**KIRKLEES METROPOLITAN COUNCIL
INVESTMENT & REGENERATION SERVICE**

**DELEGATED DECISION TO DETERMINE APPLICATIONS FOR
CONSENT, AGREEMENT OR APPROVAL REQUIRED BY CONDITION**

Reference No:	2026/44/90110/E
Site Address:	Adj, 497, Penistone Road, Shelley, Huddersfield, HD8 8HY
Description:	Discharge of details reserved by conditions 4 (materials), 11 (boundaries), 12 (bin storage) on previous permission 2024/93278 for erection of detached dwelling with parking area partly shared with other properties and associated external works
Recommending Officer:	Elenya Jackson

client	MR I HELEINE		
project	NEW DWELLING LAND ADJACENT TO 497 PENISTONE ROAD SHELLEY, HUDDERSFIELD, HD8 8HY		
drawing	DETAILED SITE PLAN		
revision	notes	date	drawn
A	BIN STORAGE INCREASED	03.26	MG
scale :	1:50 AT A1	01.26	MG
project no.	drawing no.	revision	
2460	02	A

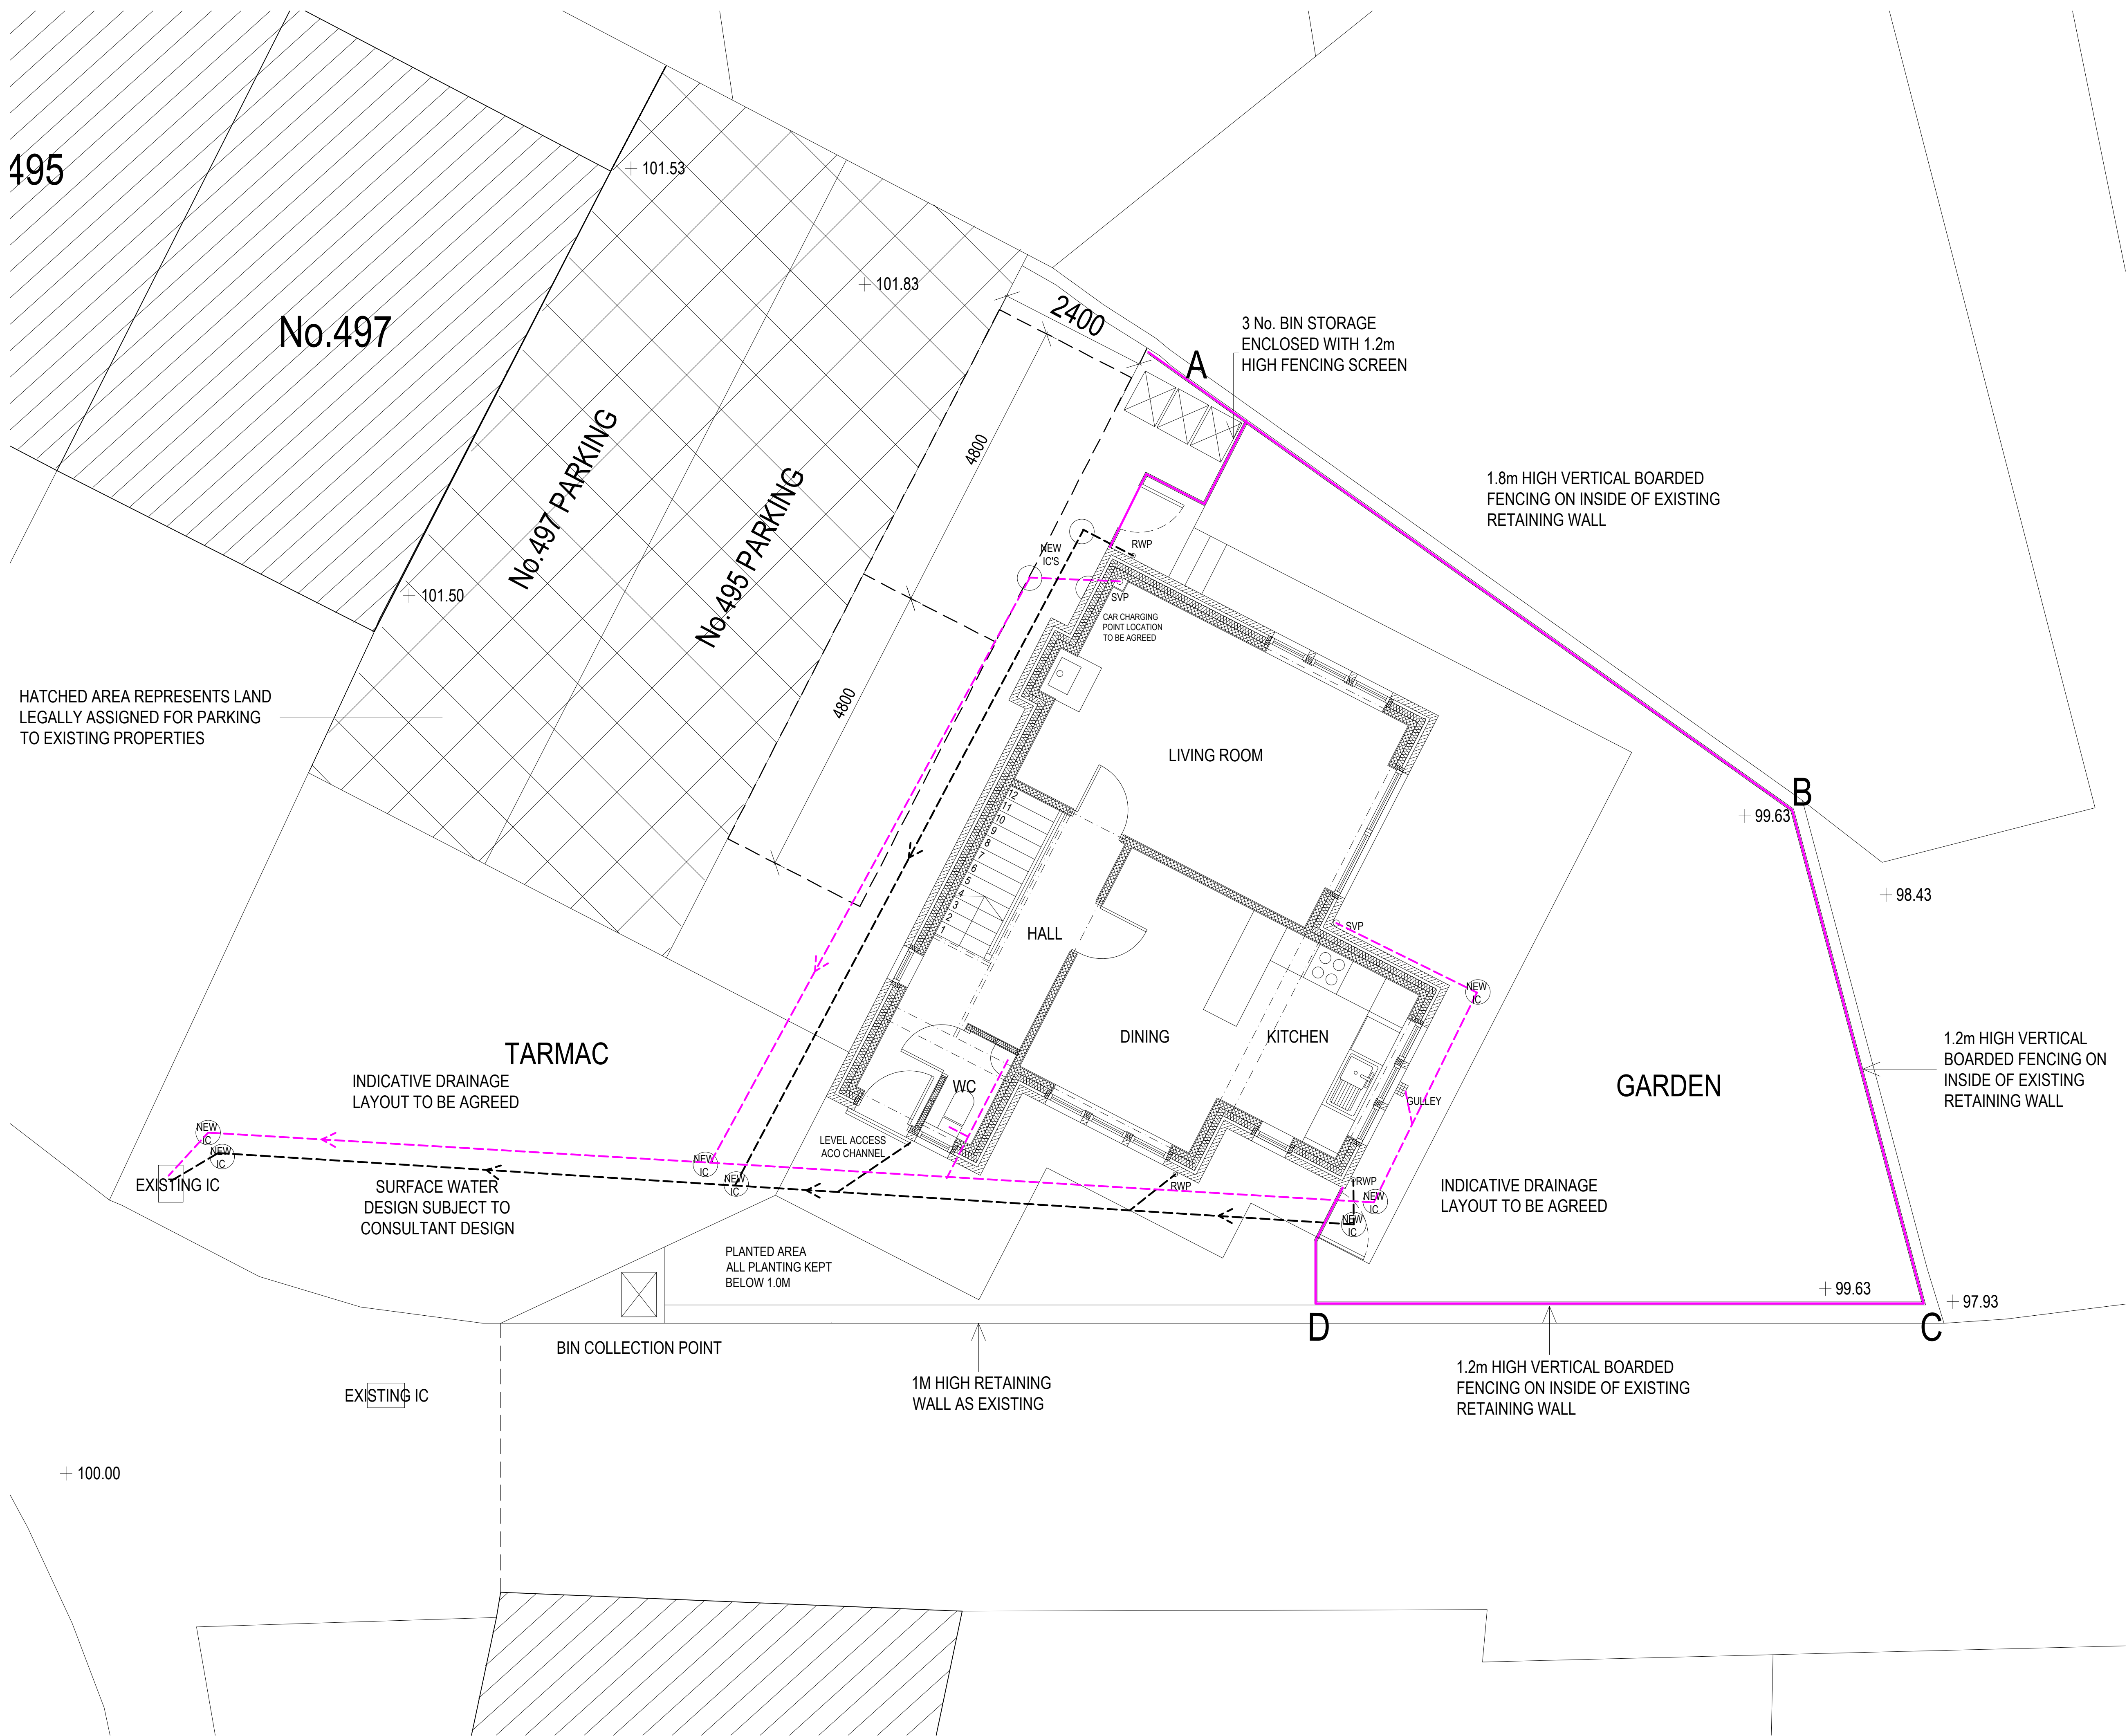
The details provided have been reviewed and considered acceptable for the purpose of discharging condition 11. The development shall then be completed in accordance with the approved details before the dwelling is first brought into use and thereafter retained.

The details provided which demonstrate the location of bin storage and collection points on site. The plans have been reviewed with KC Highways and have been considered acceptable. The approved details shall be provided before first occupation and shall be so retained thereafter
